**Consultation Response from KC,  
Conservation & Design**

**2026/91009 4-6, Kirkgate, Huddersfield, HD1 1QH**

**Listed Building Consent for roof repairs including re-use and replacement of slates, new underlay, battens and leadwork; replacement rainwater goods; repointing and masonry repairs; chimney repairs; and minor basement structural repairs (within a Conservation Area)**

**Date Responded:20/5/26**

**Title:** Proposed Basement Repair Works

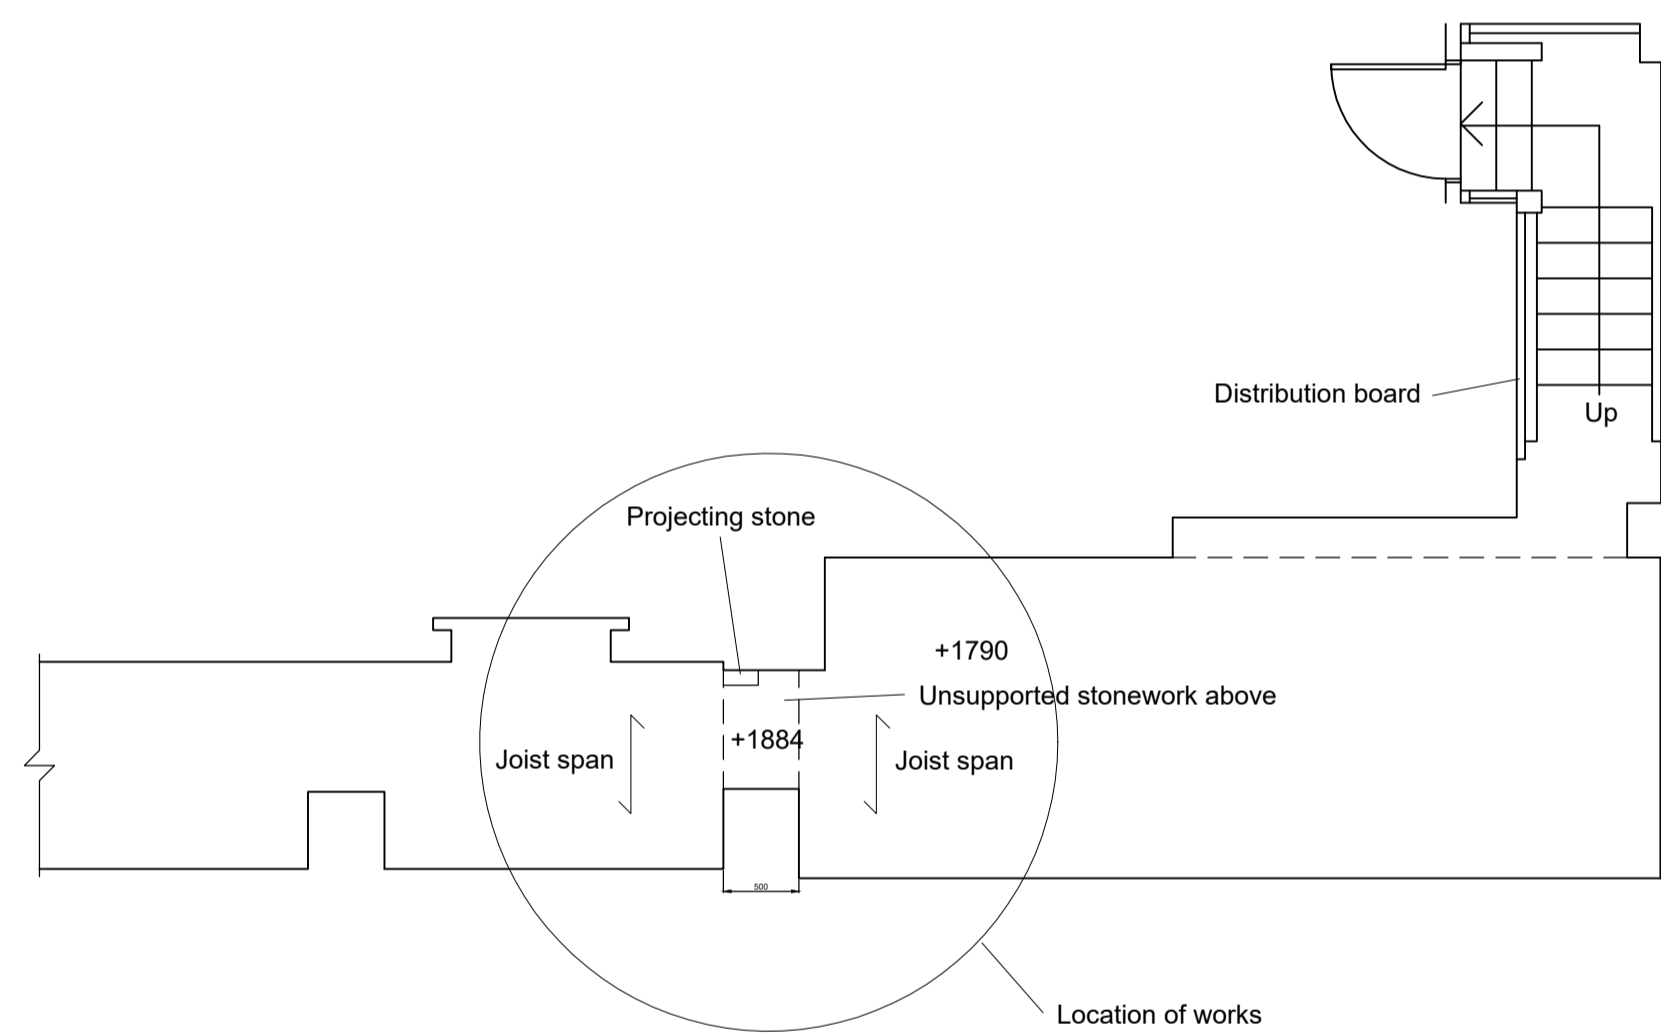
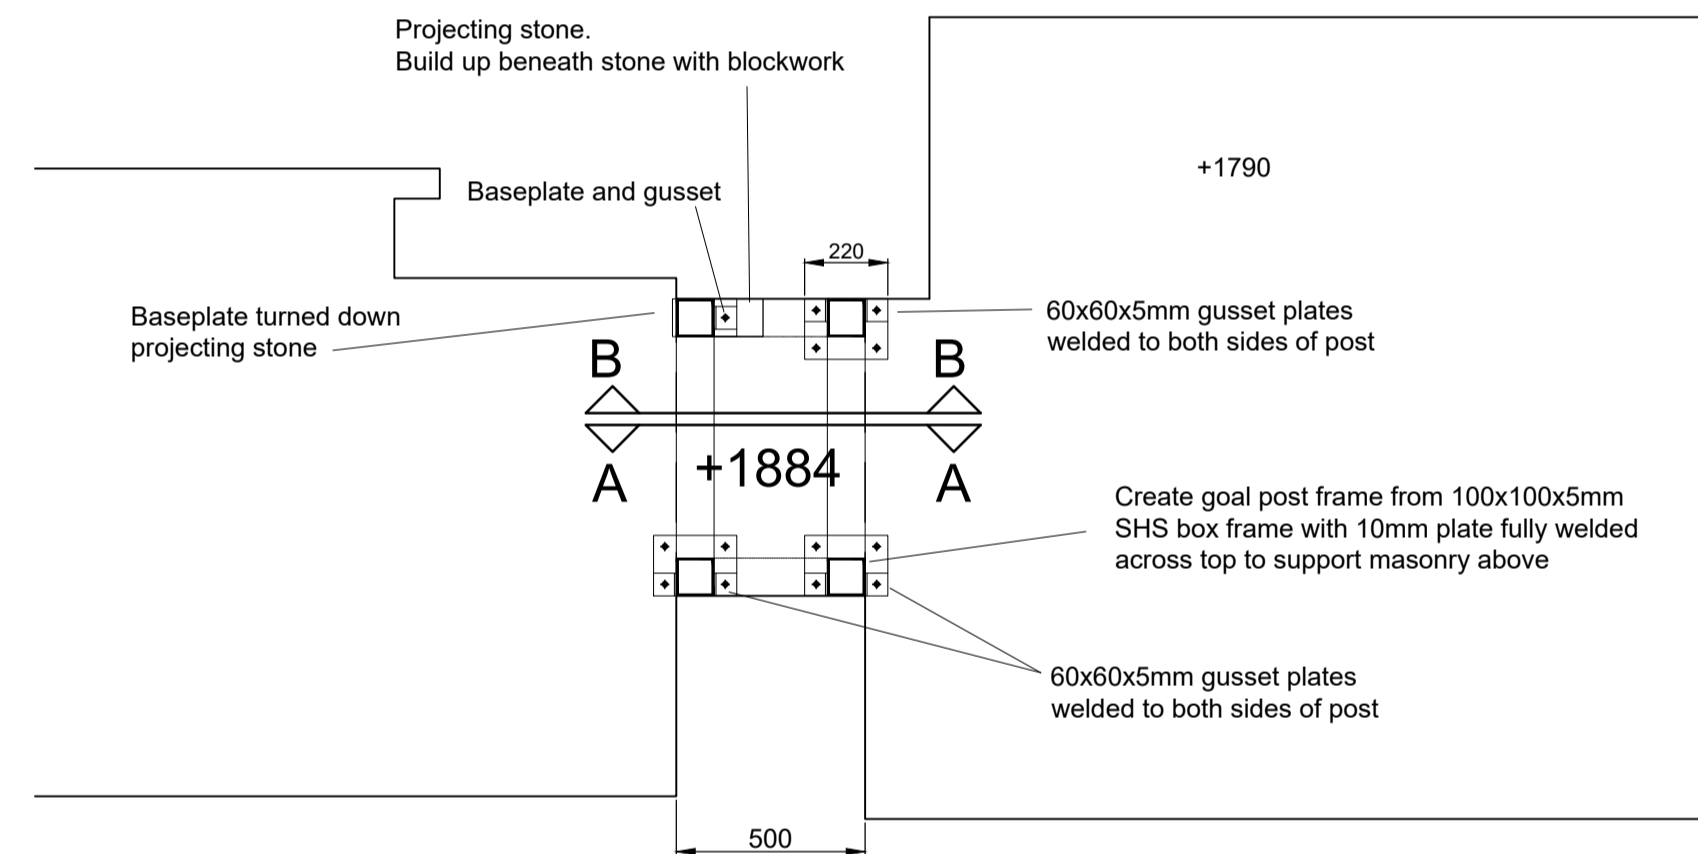
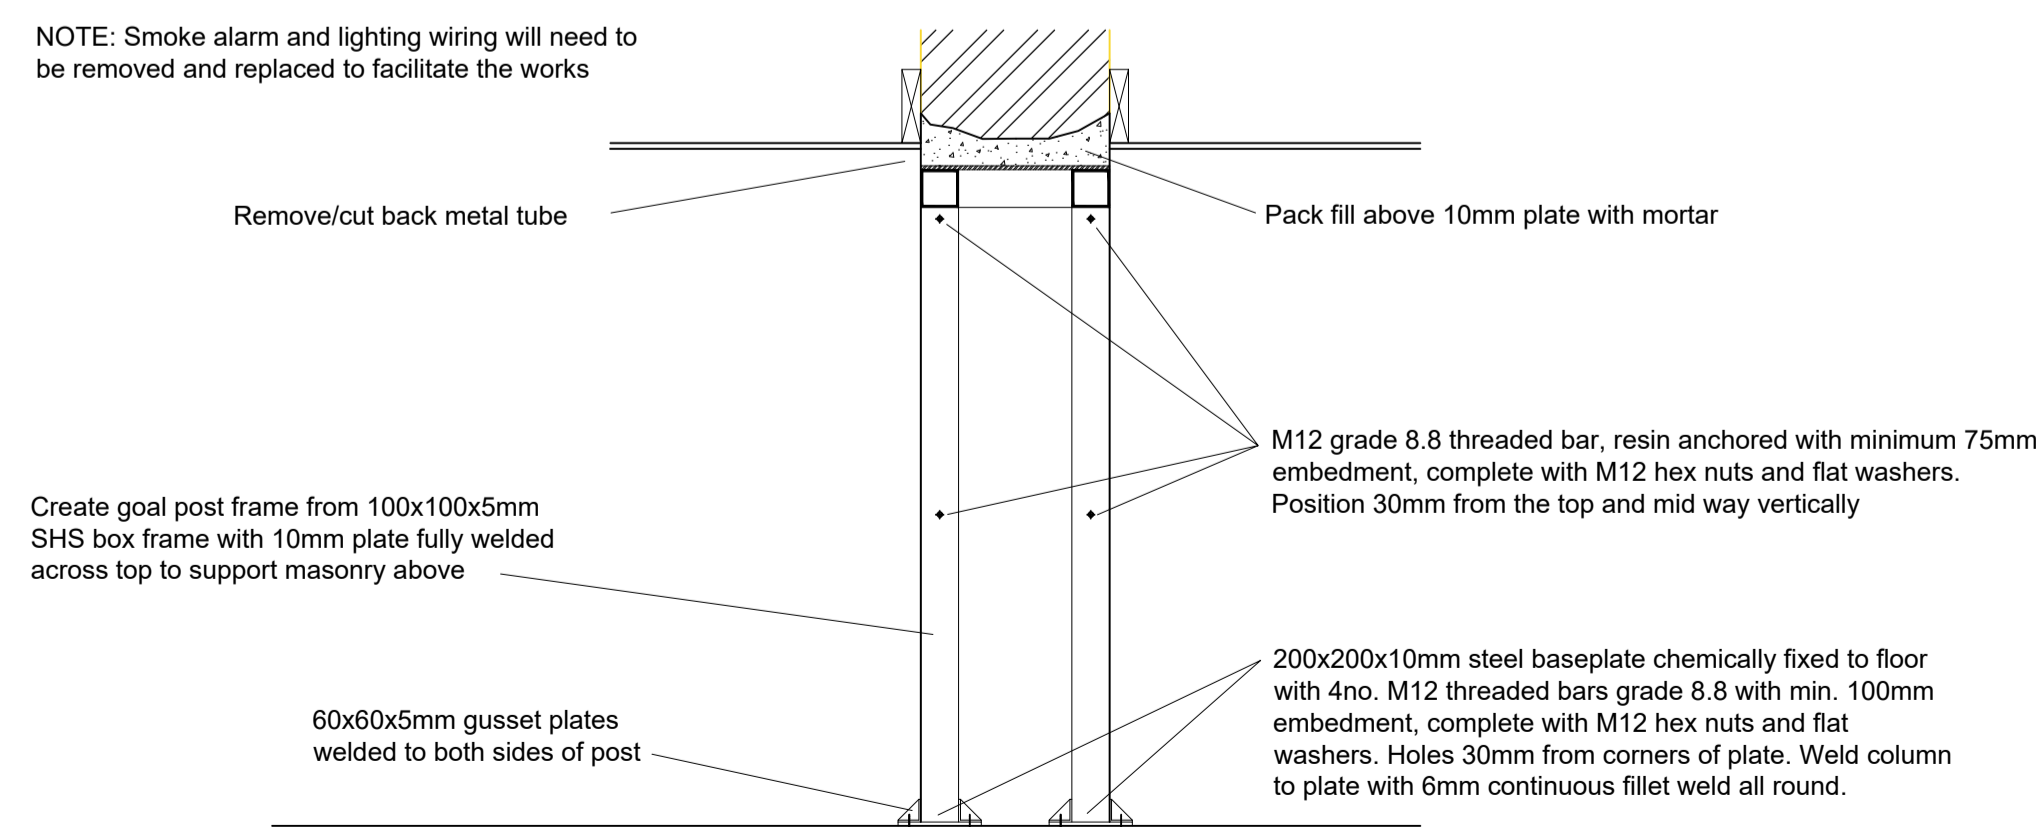
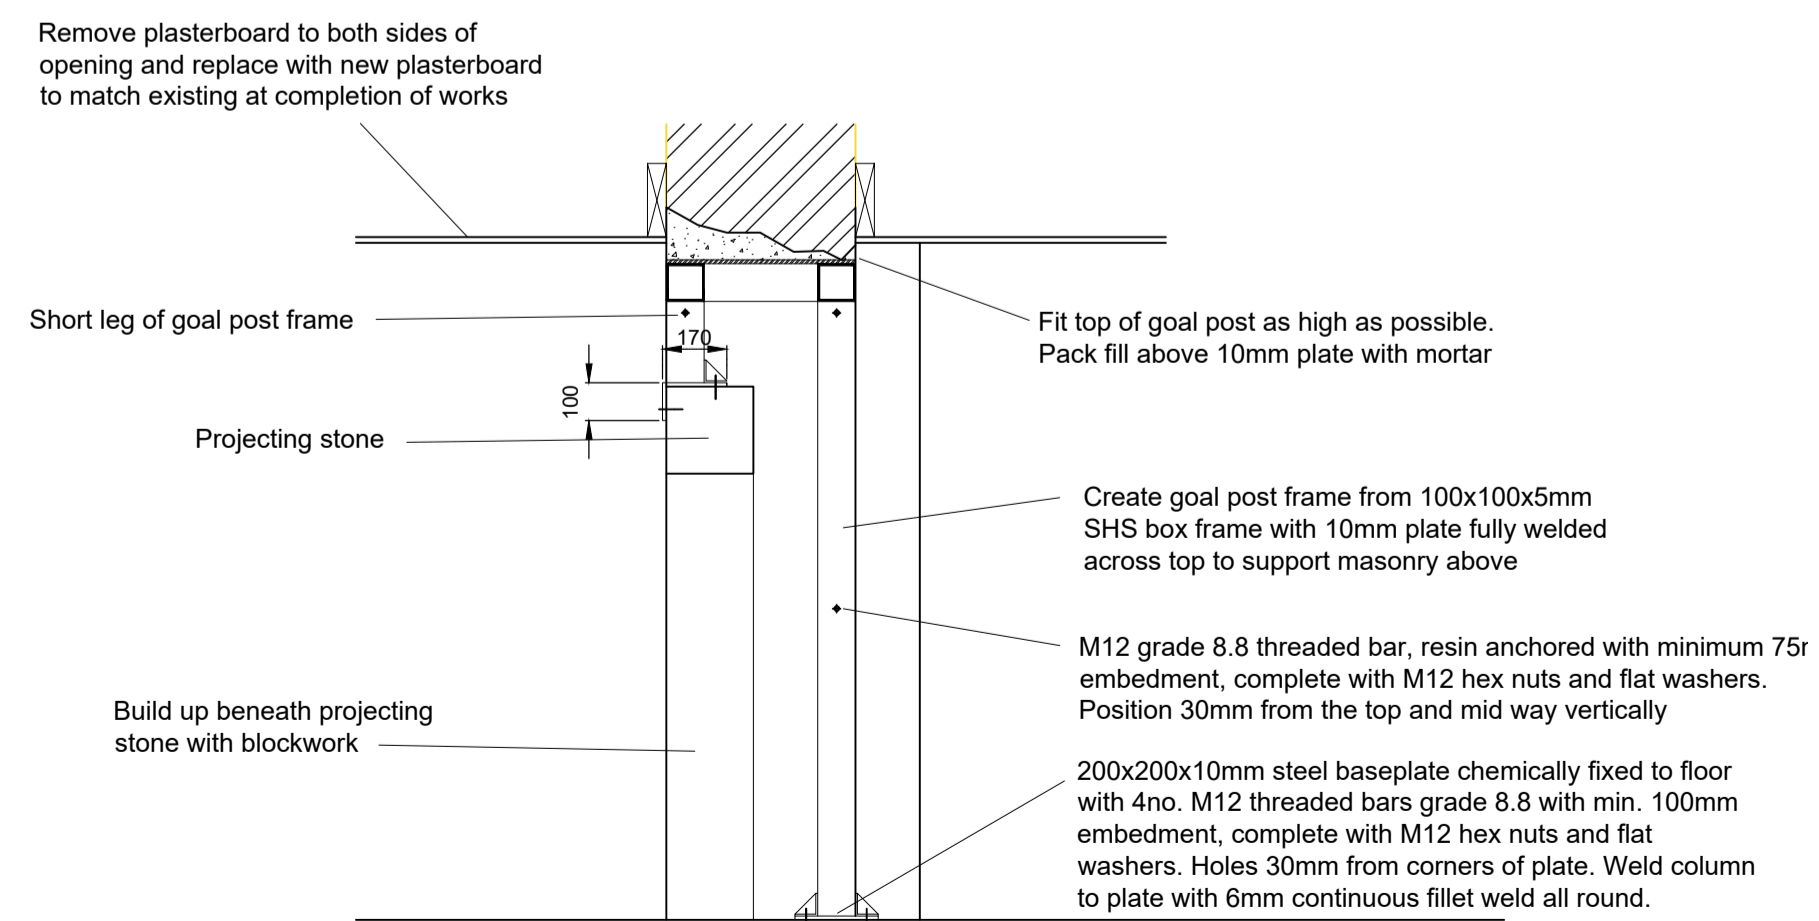
It appears that some structural repairs are required in the basement, and although these would be of modern construction using steel goalpost frame to support existing masonry, it appears that these would be minimalist and reversible, and within an area that is not highly prominent, so would not impact the historic significance in this case so would likely be acceptable.

**Title:**  
 Proposed Roof Repair Works

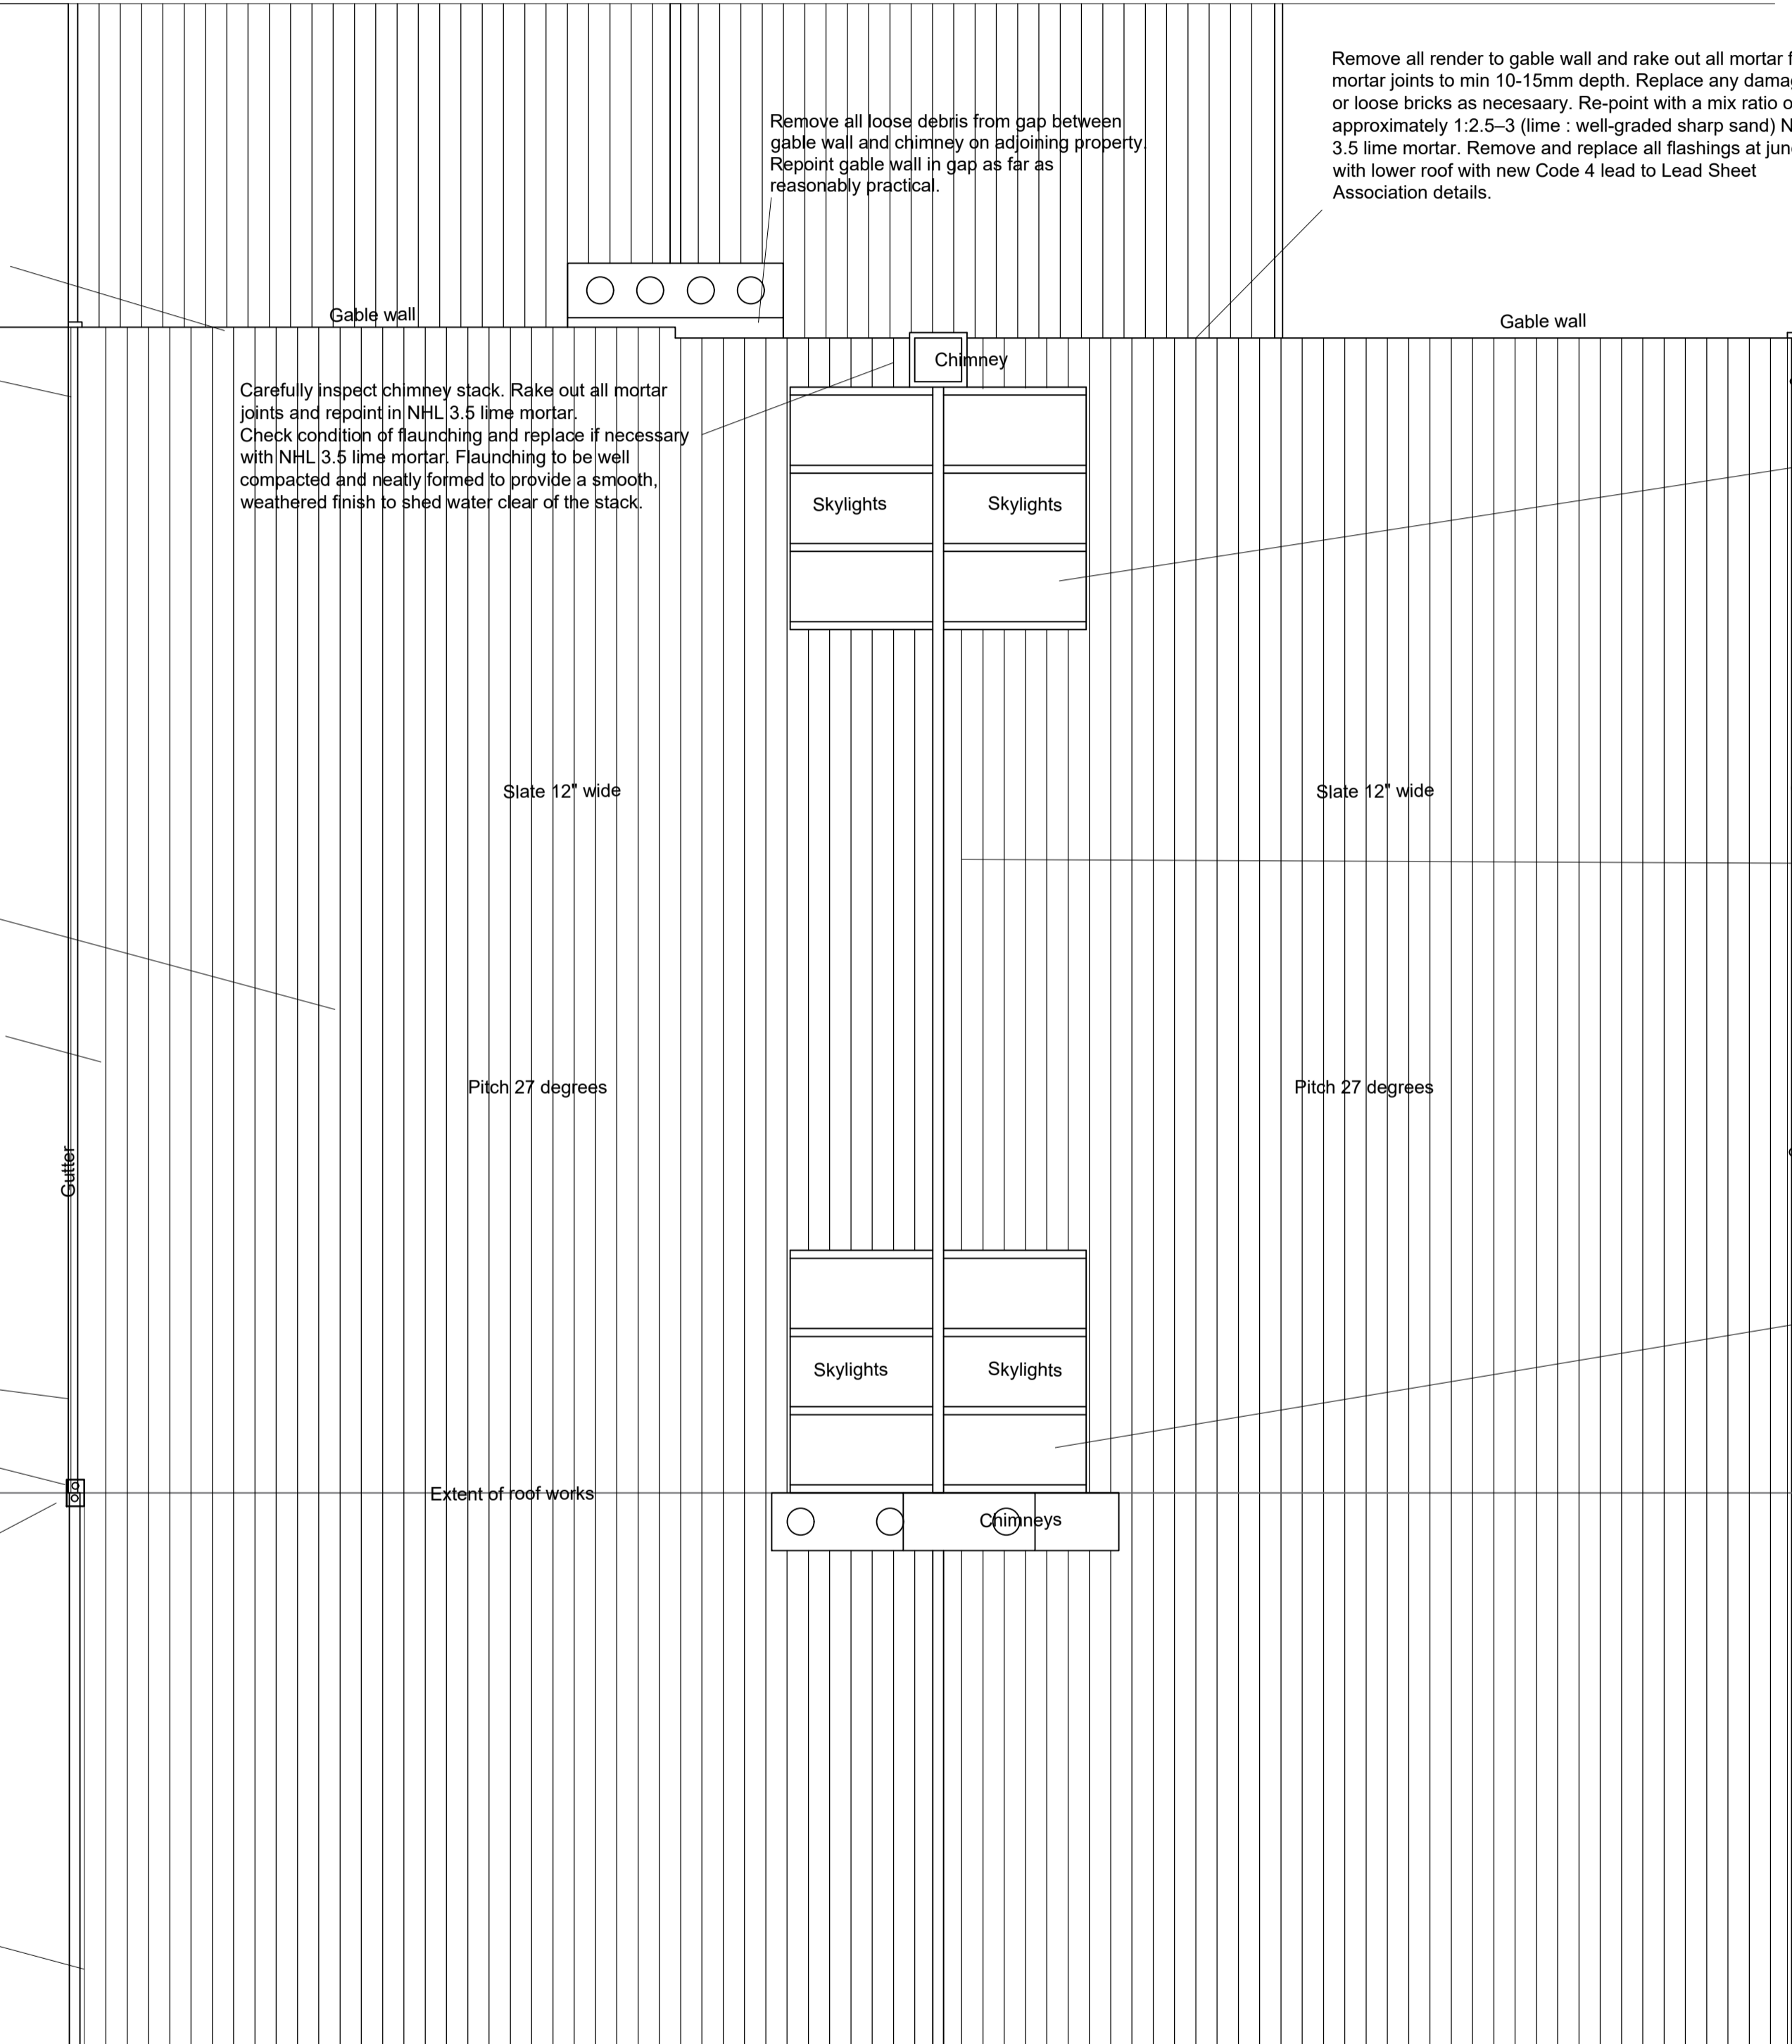
Localised timber repairs will be undertaken only where necessary, including splicing of decayed rafter ends. This is considered acceptable.

We note that some render would be removed and the gable end re-pointed with lime mortar. It appears that there is a mix of some stone, some brick and some render on the gable end. The use of an appropriate lime mortar (weaker than the adjacent stone/brick), in a colour to match, to be finished flush or slightly recessed would be acceptable and a condition should be applied to ensure this. The application states that NHL 3.5 lime mortar is proposed which is acceptable.

Repairs to existing skylights is proposed with renewal of flashings in lead which is acceptable.

Rainwater goods should be cast iron, or sectional cast aluminium of a heritage profile (not plastic), finished black. A condition could be applied for this item.

We note that it is proposed to replace the broken slates (up to 50%) with matching reclaimed slate, to match in terms of colour, size, finish as closely as possible.
